RE: Pre-Development Application Meeting PDM/2019/94/1

**PROPERTY: C O'Keefe Drive ORAN PARK
LOT: 1001 DP: 1234527**

1. The proposed development involves early works for Catherine Field Primary School consisting of bulk earthworks, site establishment and stock piling.

CATHERINE FIELD PS  
NEW HIGH QUALITY CLASSROOMS  
DRAWING NAME  
GENERAL ARRANGEMENT PLAN

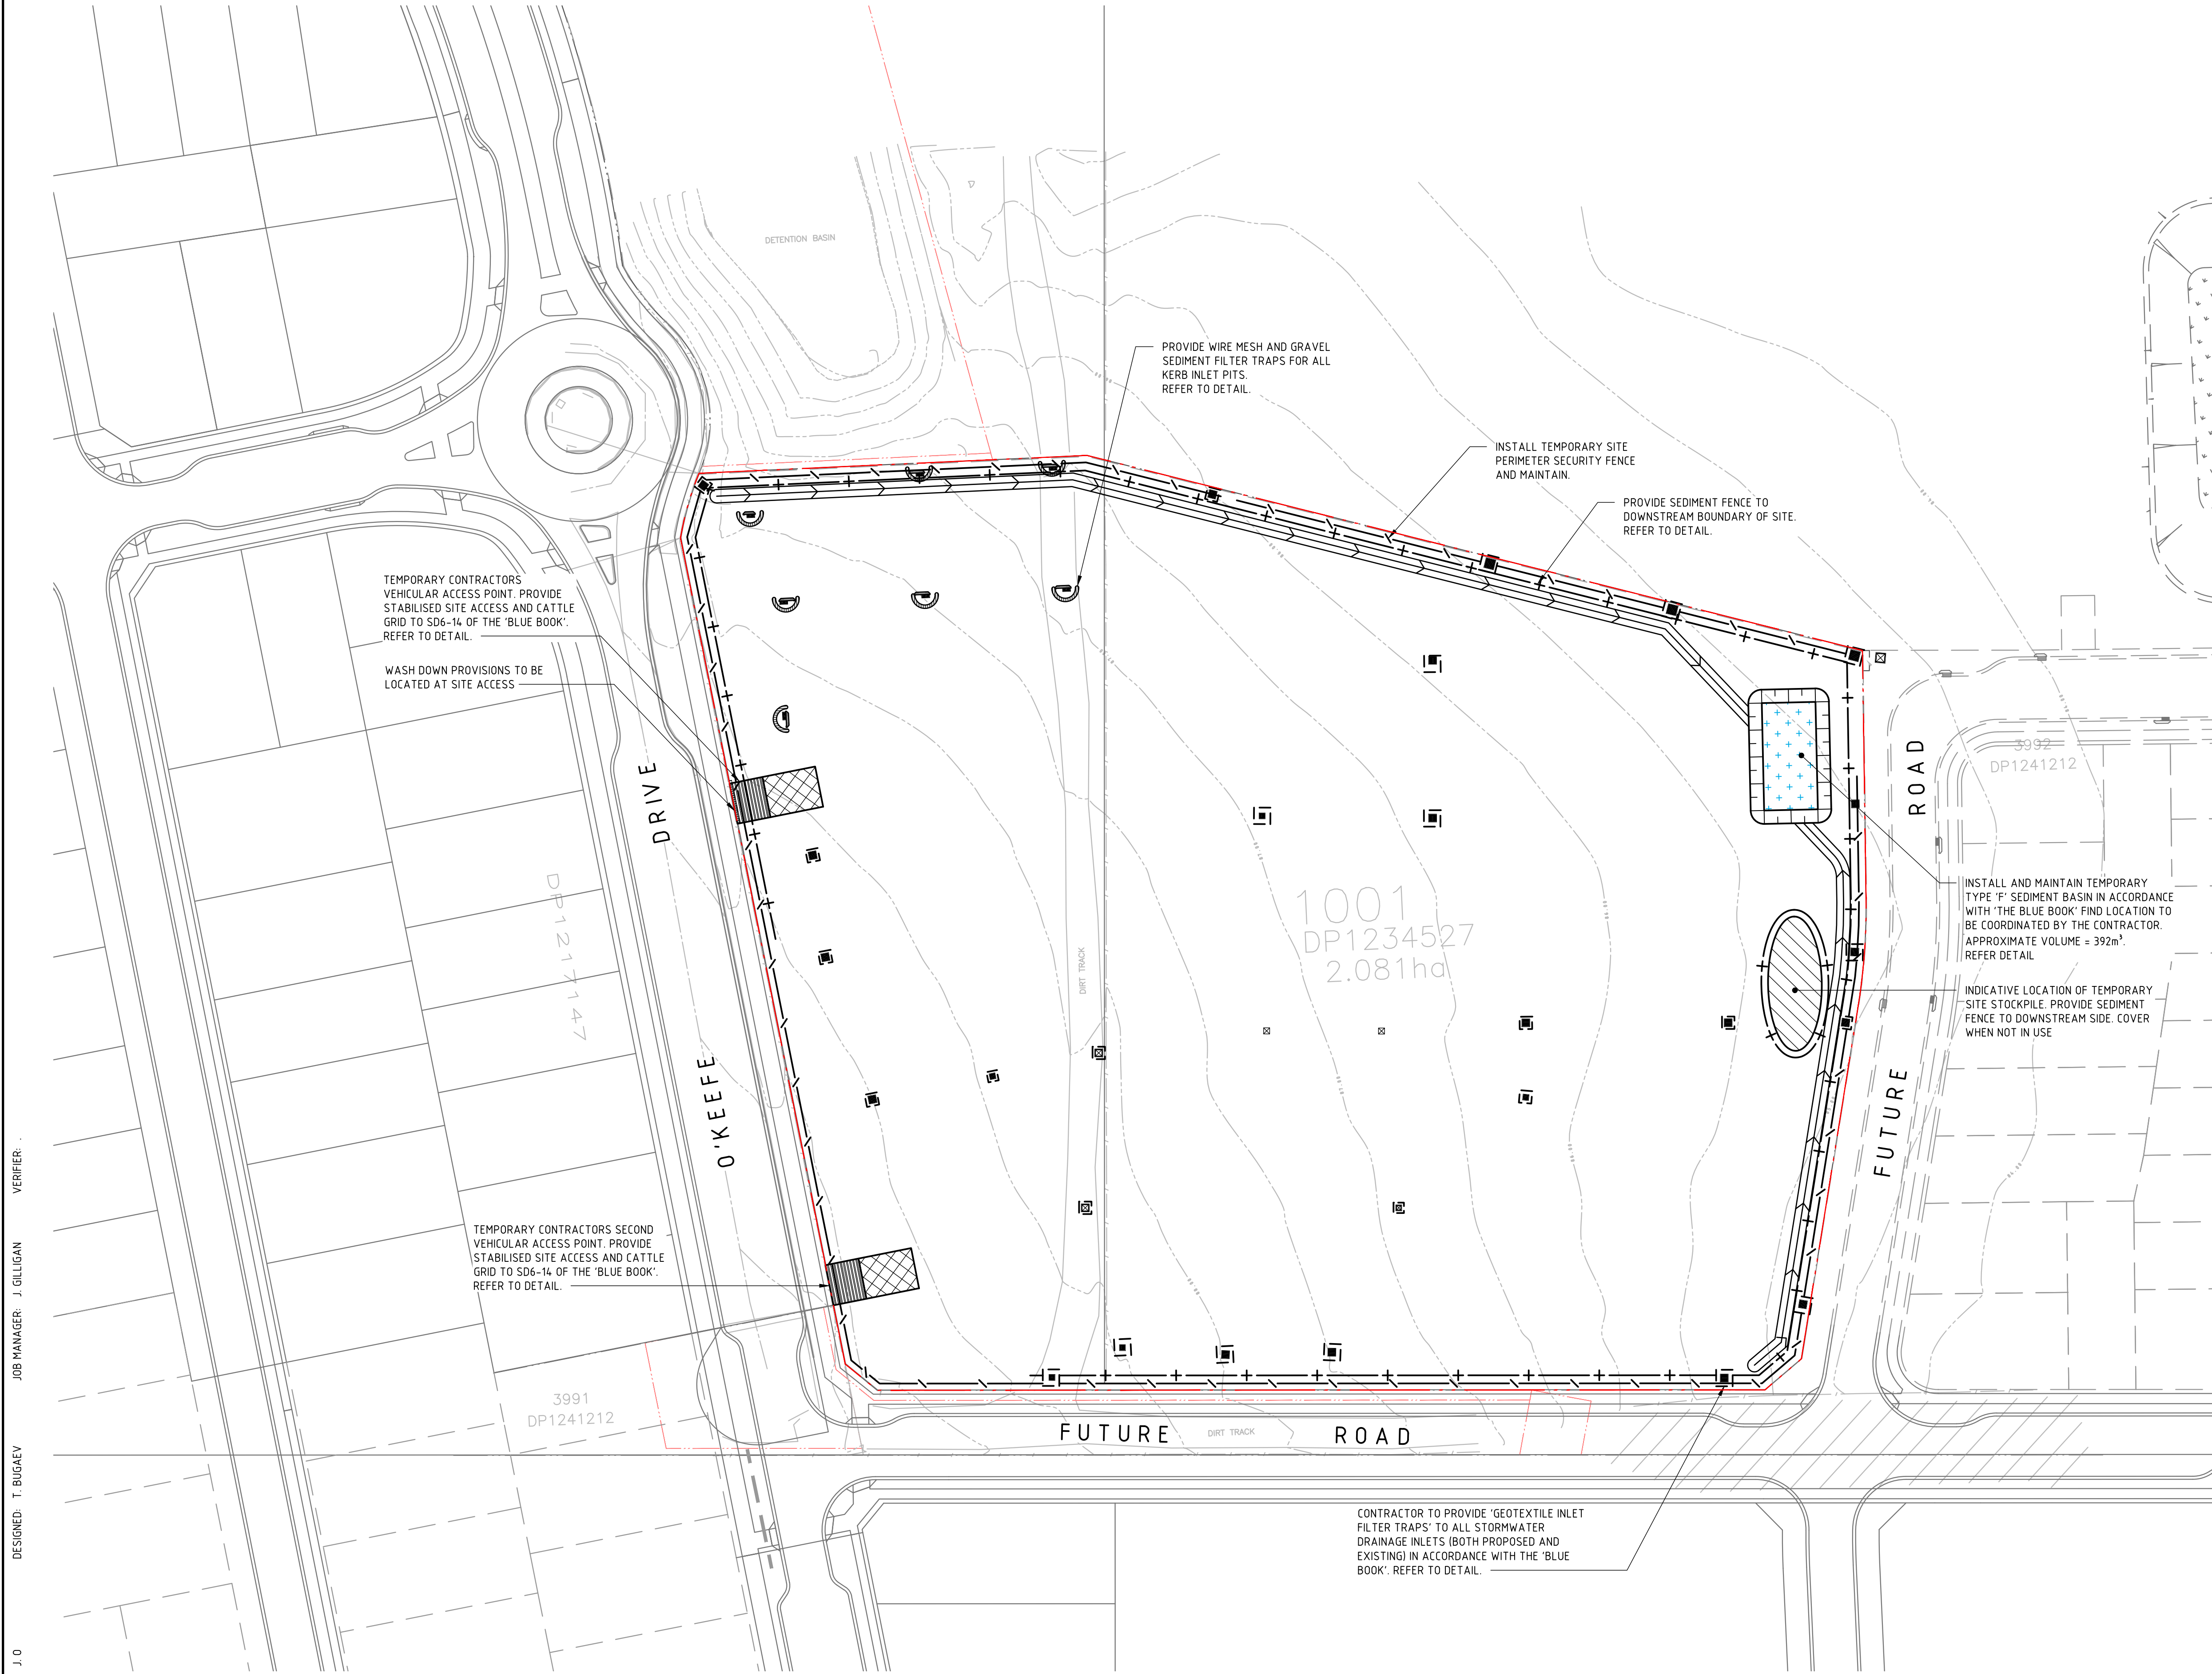
The 'existing levels' shown on the engineering plans shall be amended to reflect the approved levels of these applications depending on proposed sequencing.

7. The finished levels are to be checked against the adjoining proposed subdivisions to ensure the final heights match one another. Significant level changes adjoining boundaries are unlikely to be supported.

The difference in finished levels between the site and future roads in the south eastern corner of the site are not supported. The proposed fill and finished levels shall be reduced to minimise the adverse impacts created by the change in levels.

8. The bulk earthworks must not prejudice the outcome of the State Significant Development application (SSDA9477). The pad and associated batter provided for the future car park does not provide flexibility in the event that the design is modified.
9. Confirmation shall be provided that the easement for overhead powerlines 9 wide through the site has been extinguished. If not, a referral to Endeavour Energy is required by State Environmental Planning Policy (Infrastructure) 2007.
10. In addition to owner's consent for the subject site, owner's consent must also be provided for the relevant lot if any works or access is proposed on or from adjoining lots (rather than the road reserve).
11. The application will be notified in accordance with the Camden Development Control Plan 2019 for 14 days.

**CATHERINE FIELD PS**  
NEW HIGH QUALITY CLASSROOMS  
DRAWING NAME  
**SEDIMENT AND SOIL EROSION CONTROL PLAN**

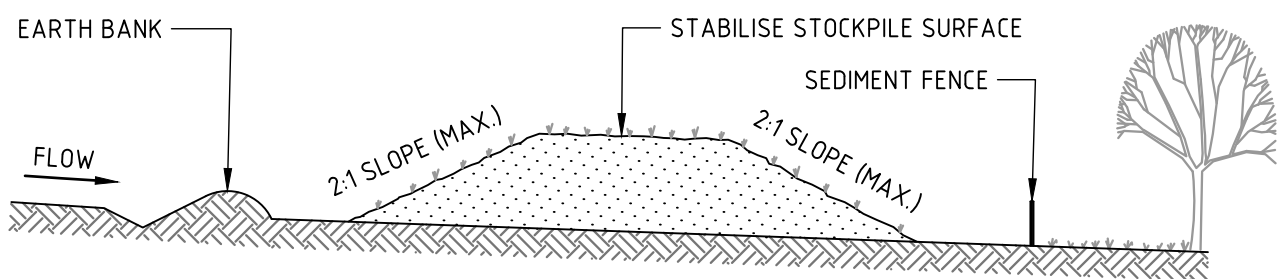
12. The entire development shall be designed and constructed in accordance with Council's Engineering Specifications.
13. Temporary site access locations are to be shown on the plans. Direct access off O'Keefe Drive is not supported due the potential impact created by turning truck movements in and out of the site close to residential houses. A temporary access point should be located at the southern end of O'Keefe Drive. This will also protect the existing kerb and gutter.

15. The bulk earthworks should ensure the site is able to drain to the temporary sediment basin without any trapped low points on site.
16. The existing onsite detention basin to the north of the site has an easement that appears to encroach into the proposed site. If this easement has already been extinguished, can evidence be provided demonstrating this.

17. All sediment and erosion controls to comply with relevant standards.

**CATHERINE FIELD PS**  
NEW HIGH QUALITY CLASSROOMS  
DRAWING NAME  
**SITeworks AND STORMwater**  
MANAGEMENT PLAN - SHEET 01

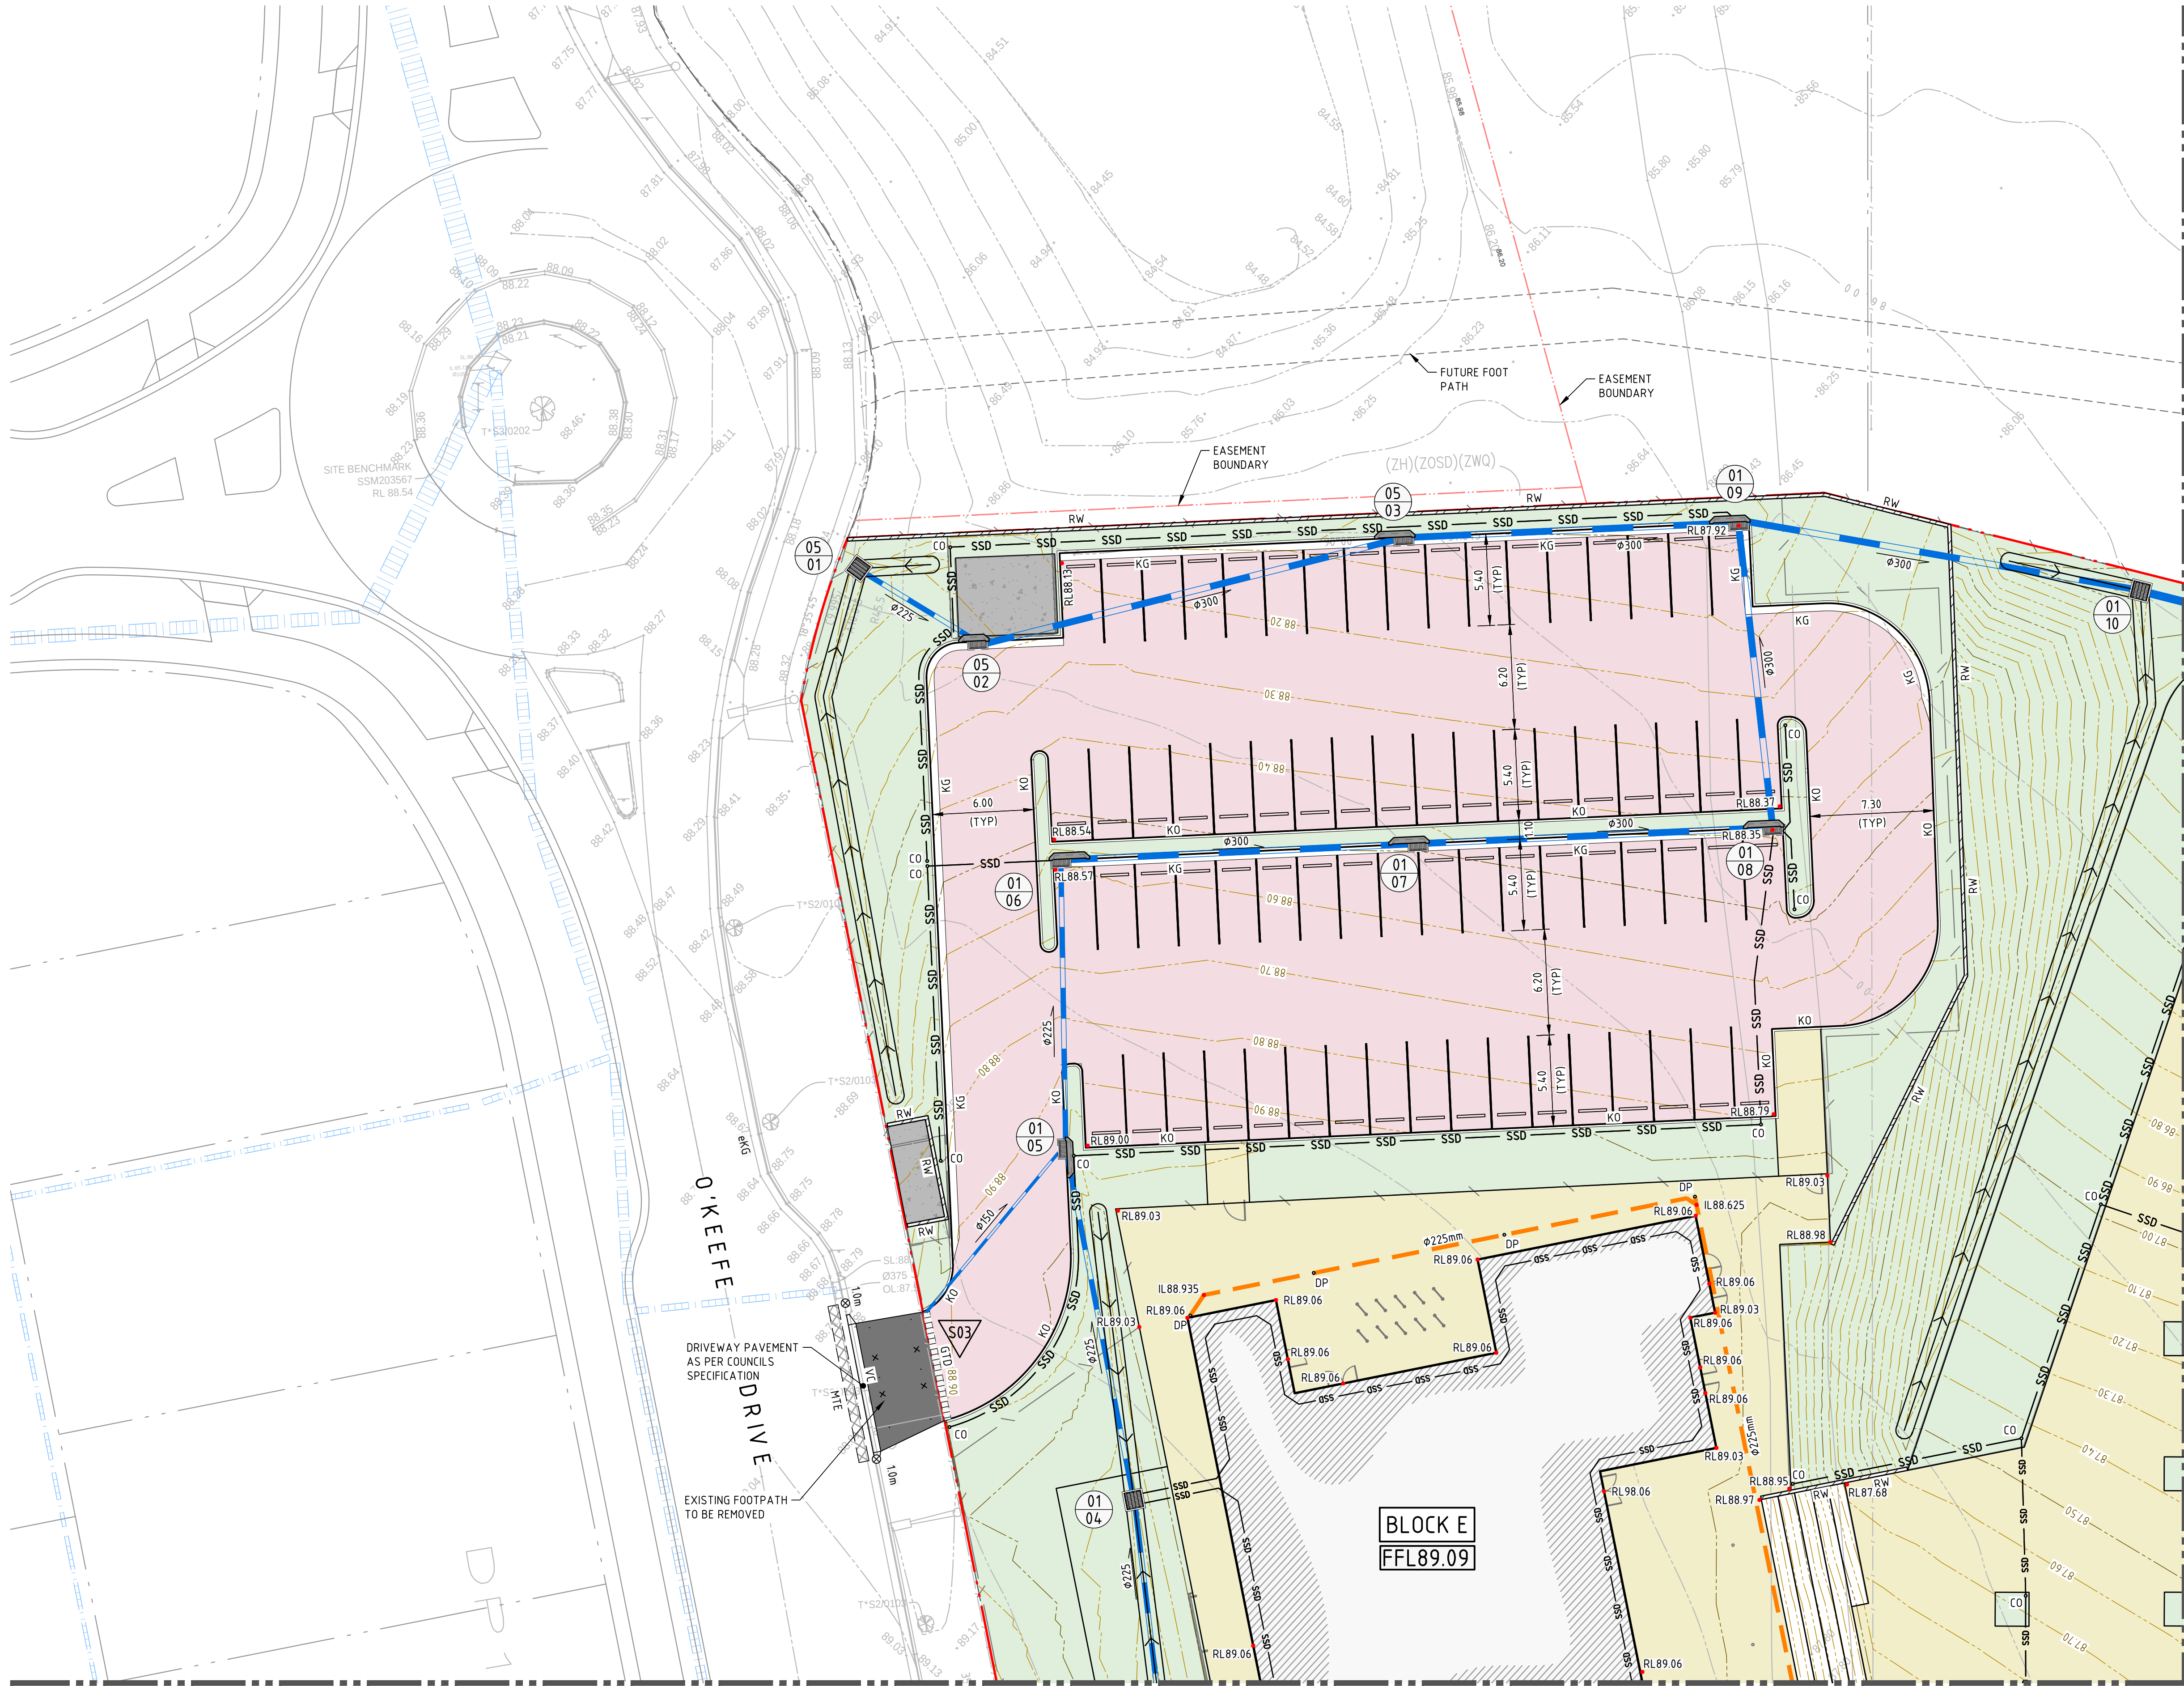
14. The bulk earthworks for the site should have batters between height differences and not vertical faces. All batter is to be a maximum of 1 in 4 (however visual impacts may require lesser gradients in visually prominent areas)
